KITITAS COUNTY

DEPARTMENT OF PUBLIC WORKS

TO: All Staff
FROM: Public Works Planning Review Team
DATE: April 15, 2020
SUBJECT: Shopbell Ranch BL-20-00010

The Public Works Department has reviewed the Request for Boundary Line Adjustment Application. In order to ensure that it meets current Kittitas County Road Standards, the applicant needs to provide the following prior to final approval:

Proposed

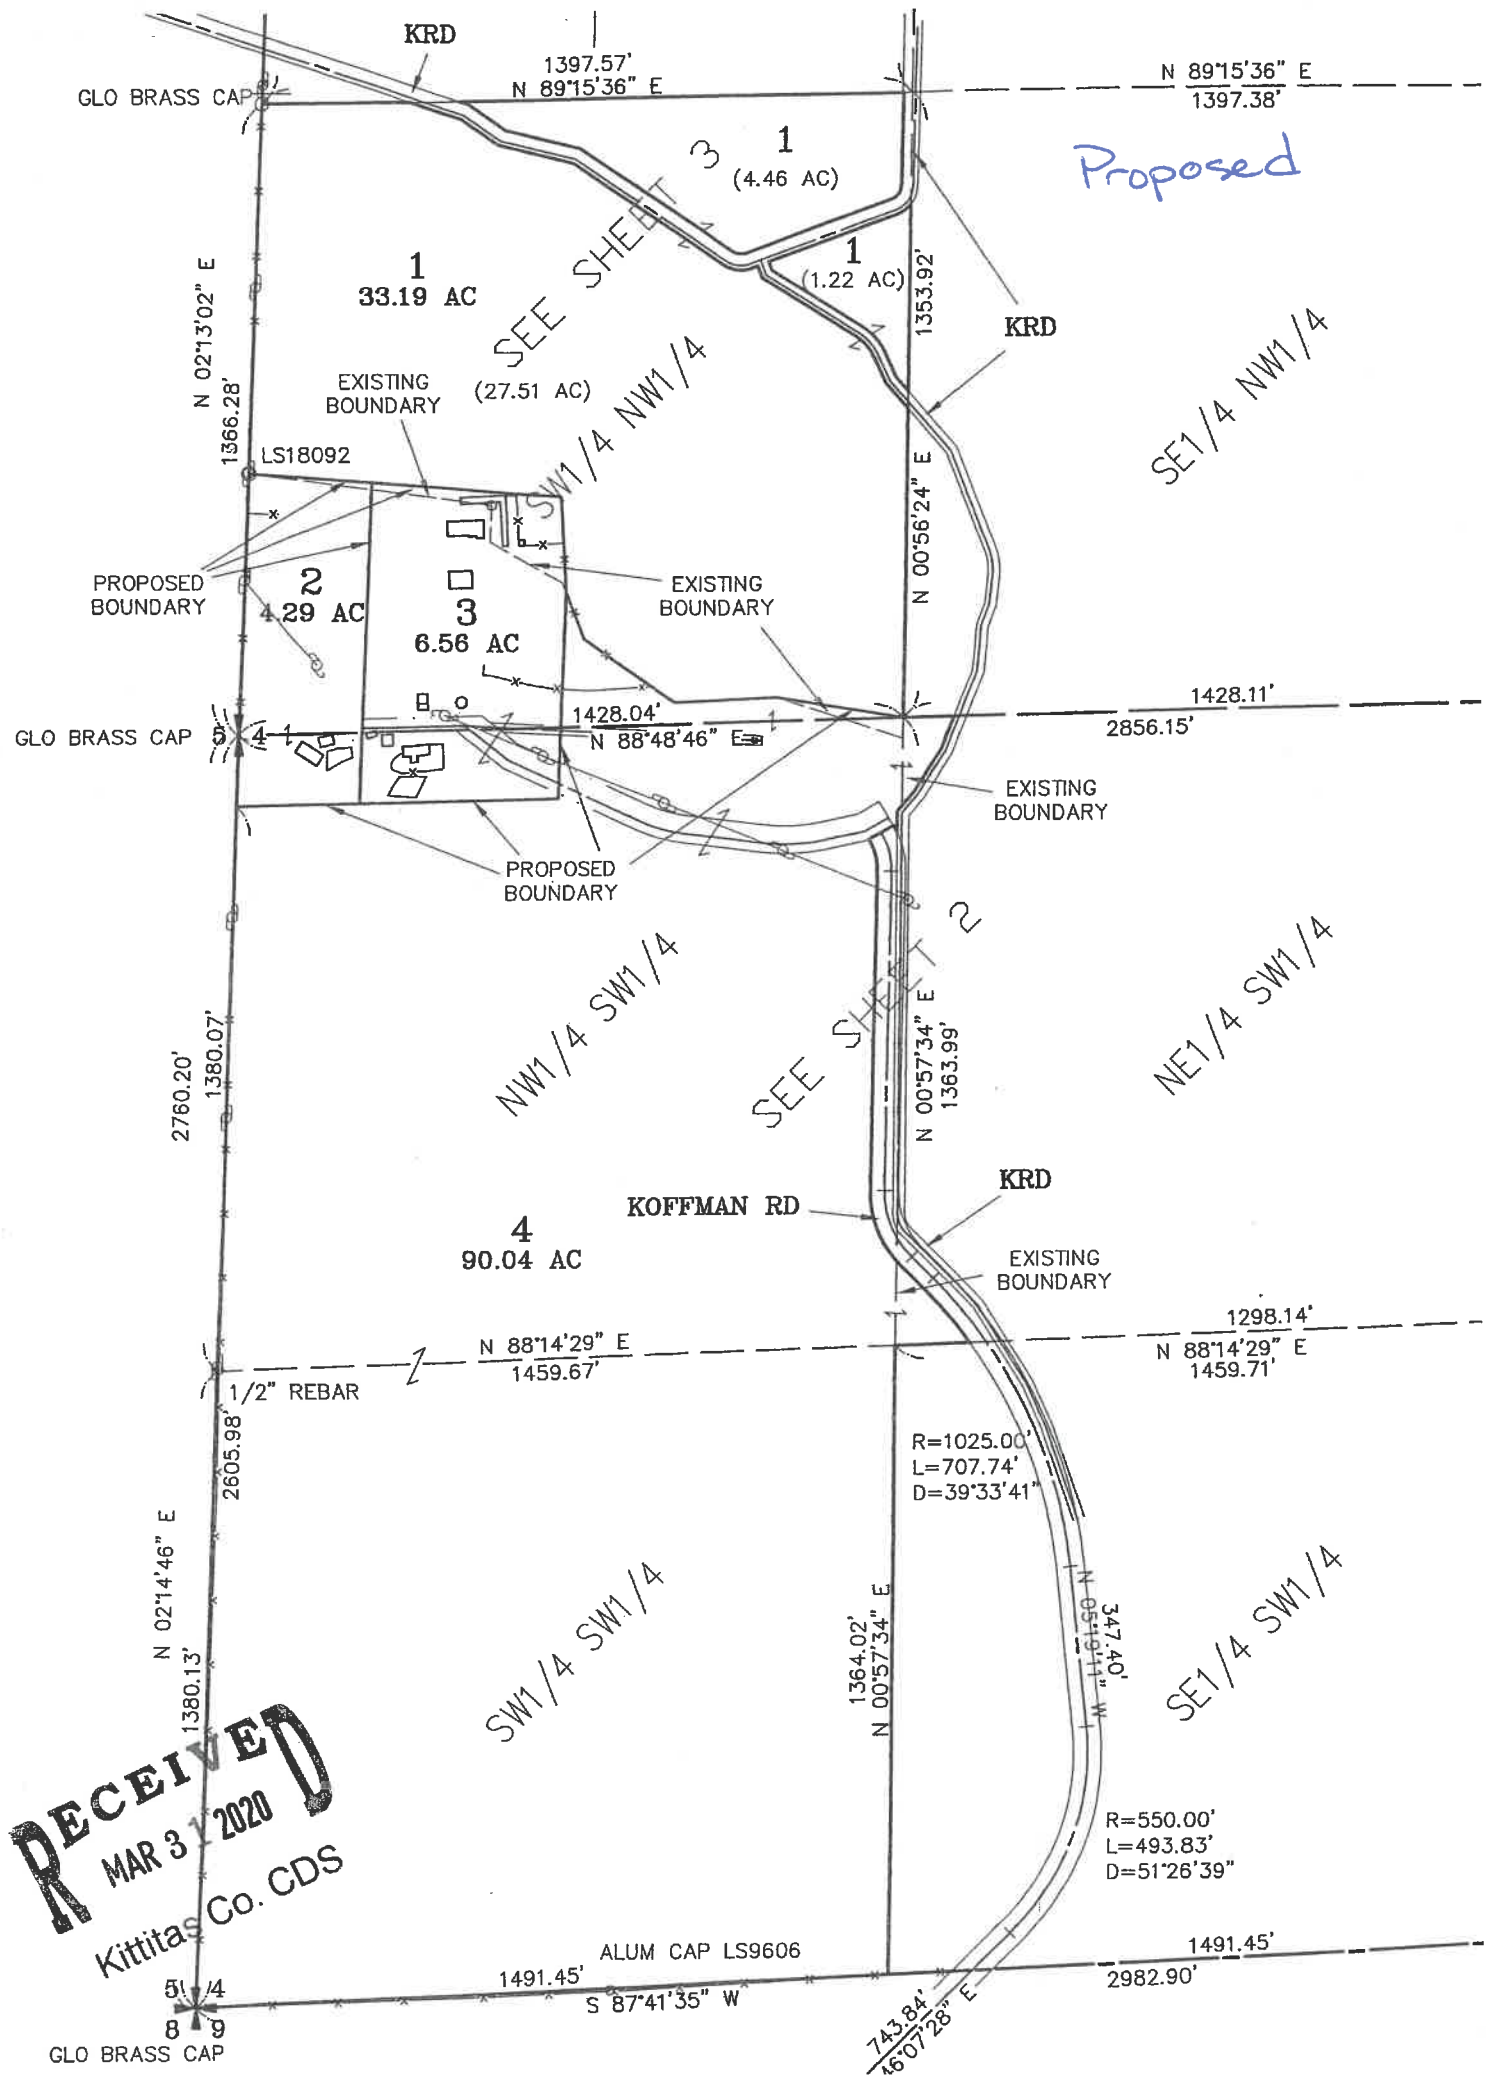
1. A revised legal description that describes the final configuration of the subject property shall be required.
2. A survey map for review.
3. Show access easements on the face of the BLA.
4. The proposed site plan does not provide access to every parcel in the BLA. Please provide legal access to every parcel within the BLA.
